CONSULTEE RESPONSE (Council's arboriculturist)

Date of report: 26 May 2022

Reference: WA/35/22/HH
Proposal: Single storey garden room extension to rear elevation
Location: Midway, Avisford Park Road, Walberton, BN18 0AP
Case Officer: Hannah Kersley

Drawing No:
Arbtech AIA 01

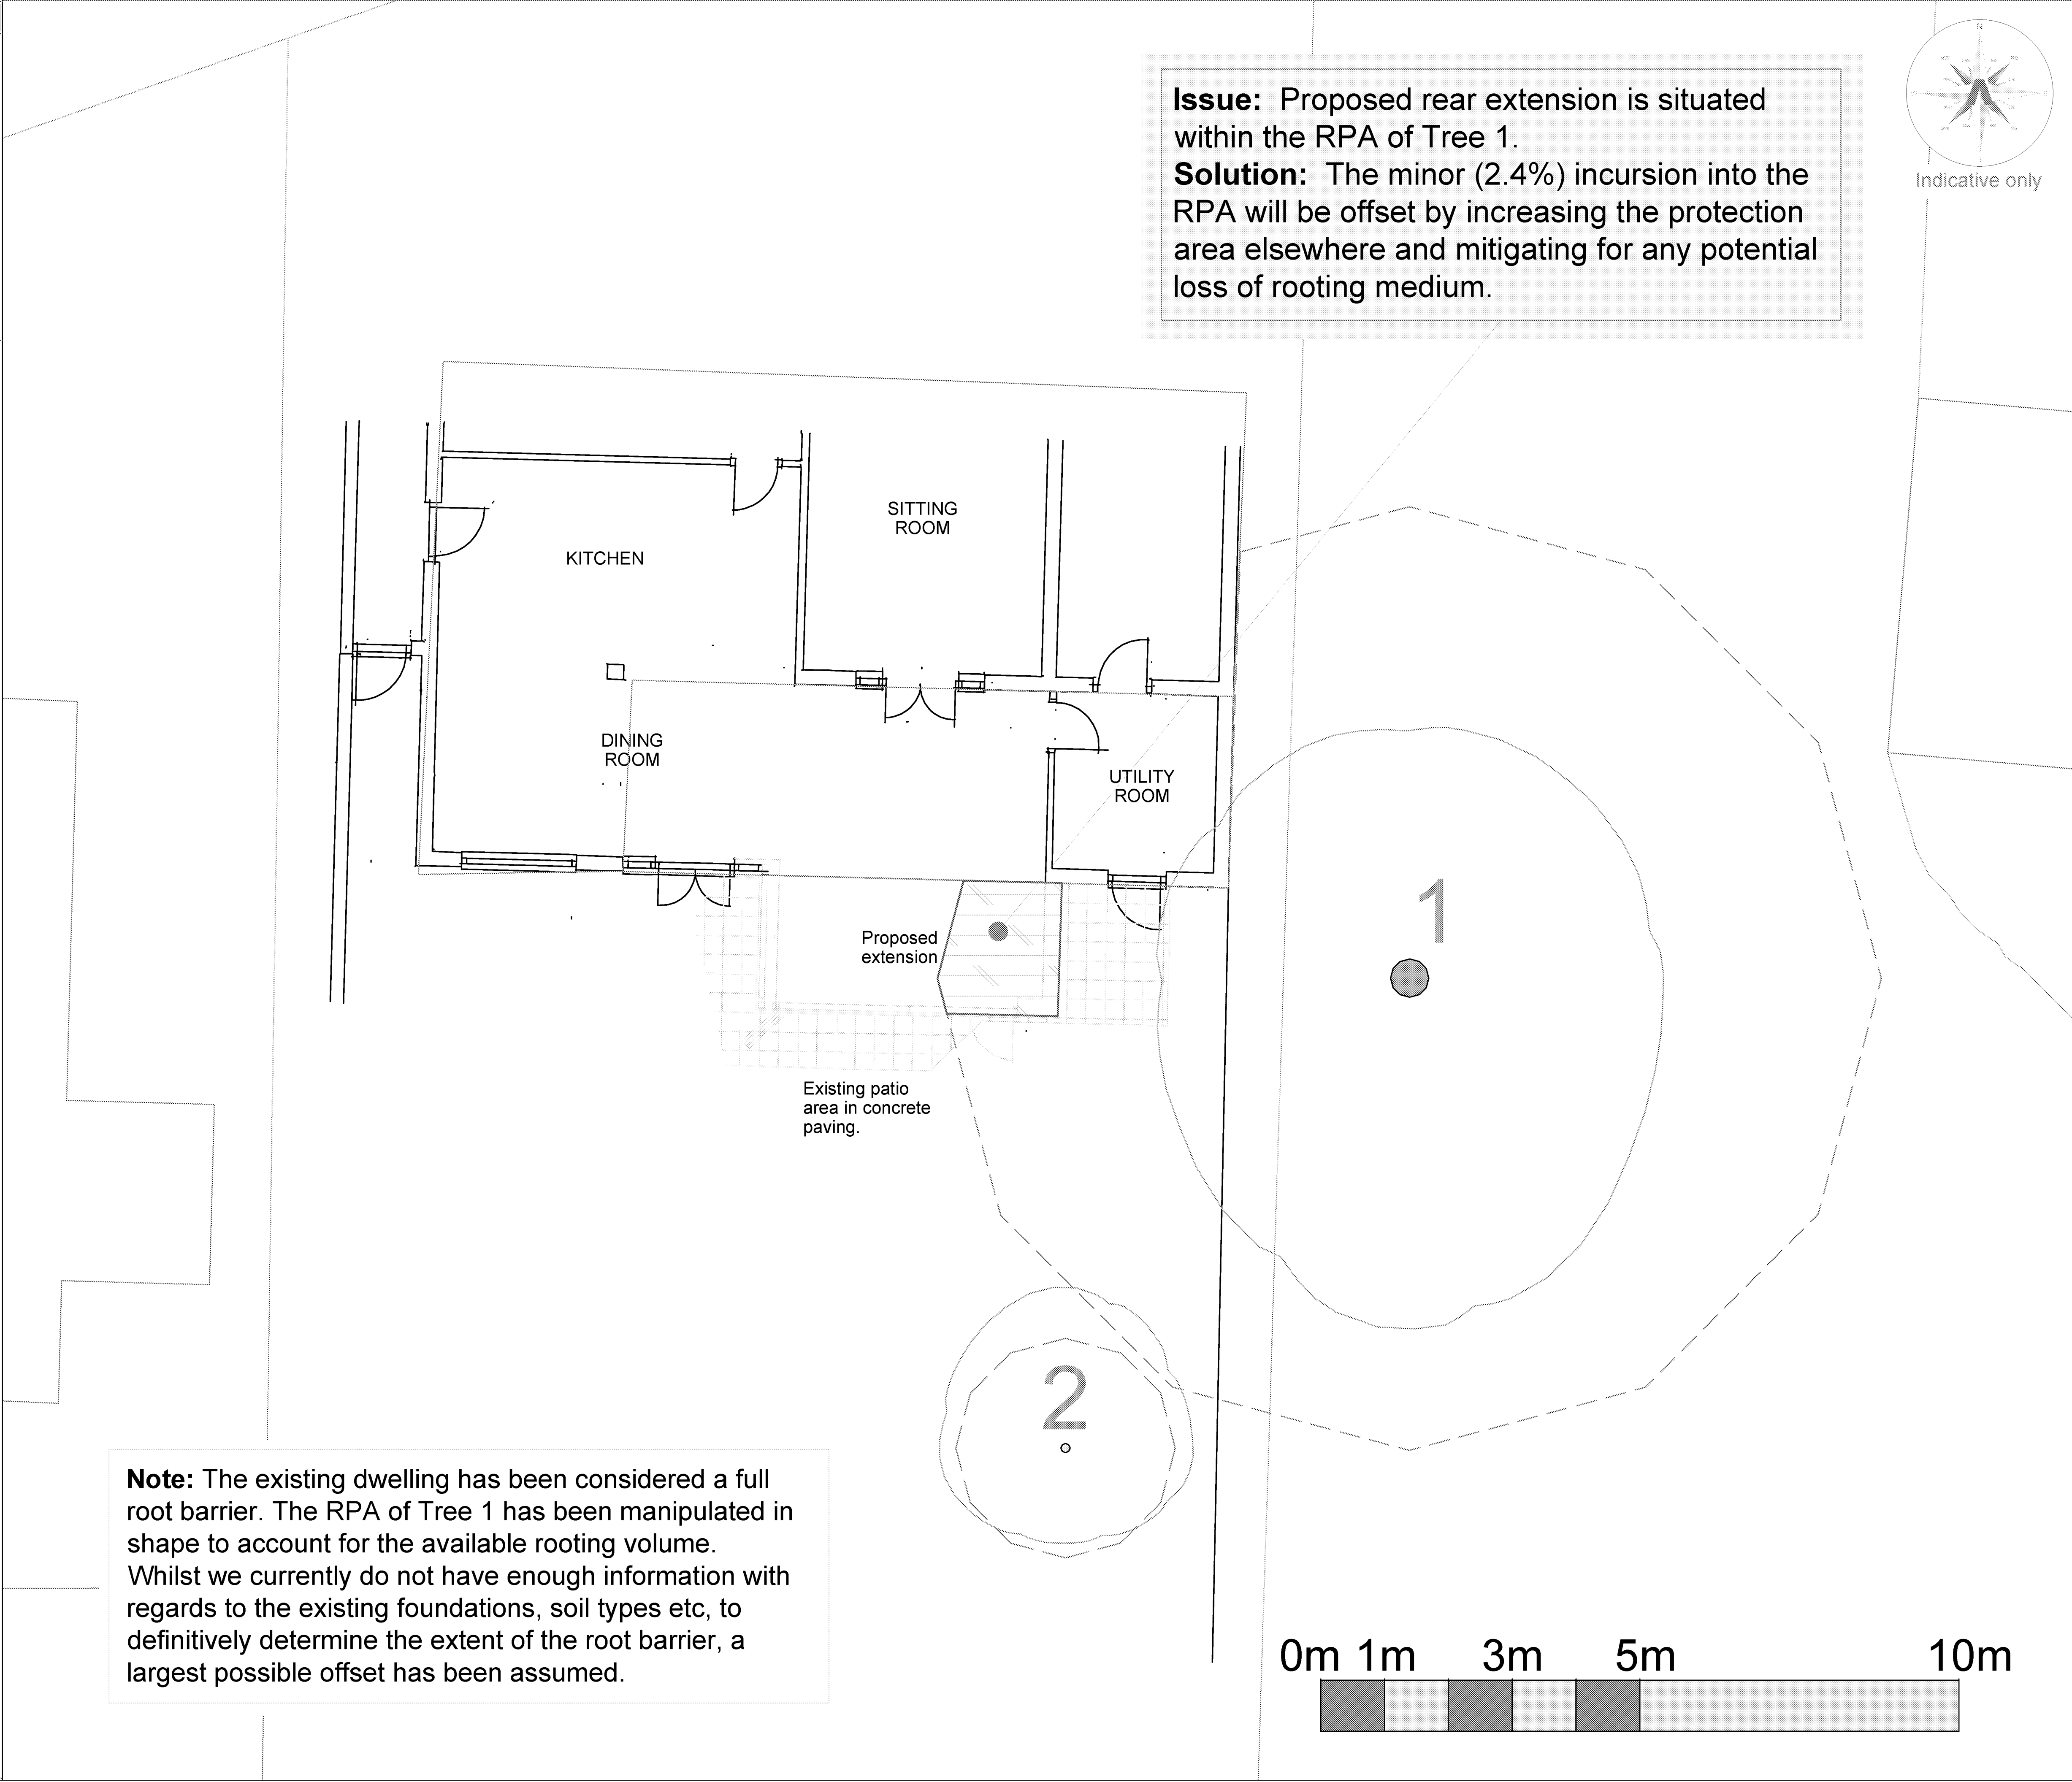
Two key elements of the applicant's Tree Survey do not correspond with my own reading and interpretation throwing into doubt the likely extent of root protection area (RPA) incursion, which I consider to be more intrusive than illustrated.

I challenge their reading of tree distance to boundary. They have measured from stem base centre to projected building line as 2.8m. I measured 2.05m.

It is stated that the shape of RPA has been manipulated to account for irregular root morphology of T1 although I see no evidence of that in the TPP or AIAMS. Based on the information provided, I find the use of a circular nominal RPA (as they have shown) likely to be broadly representative and adequate for determining this application.

The applicants will need to instruct their Arboricultural Consultant to submit a **revised** Tree Protection Plan and AIA/MS (Table 4) RPA Schedule.

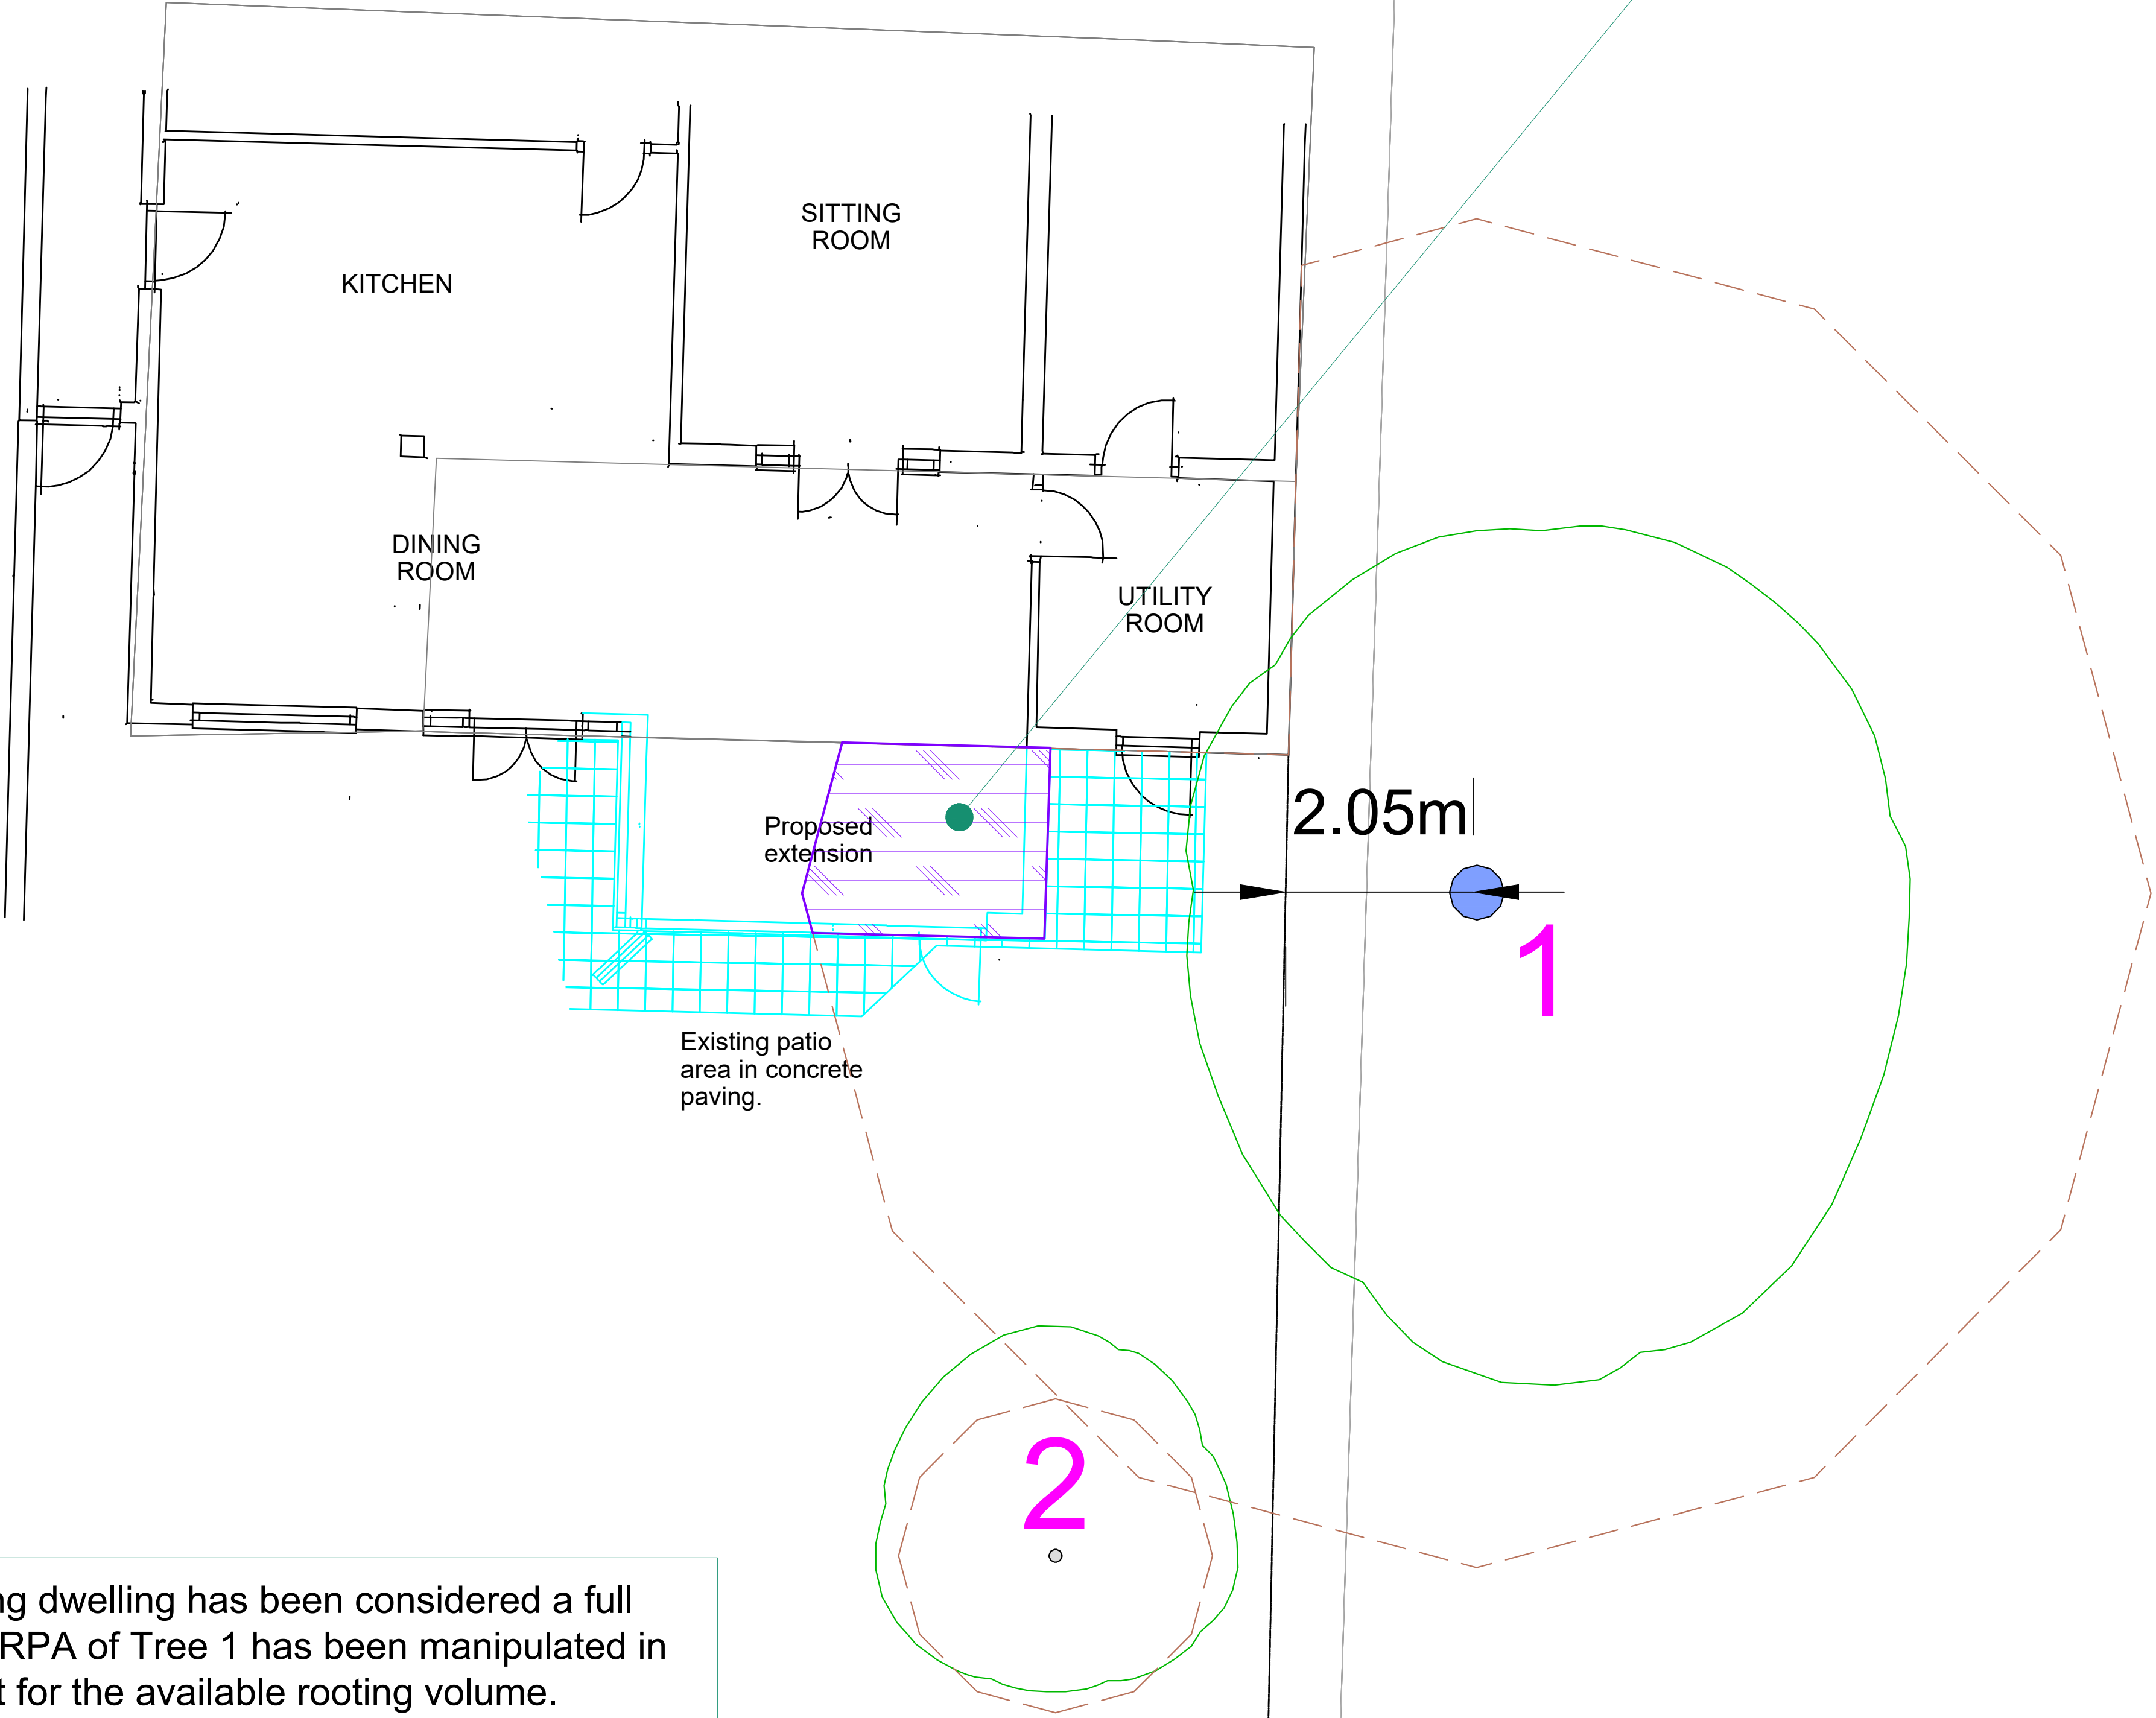
The development proposal is achievable without undue detriment to retained trees, although we must be in possession of an accurate Tree Protection Plan, to ensure adequate illustration for the benefit of all interested parties and importantly for those contractors employed at site.
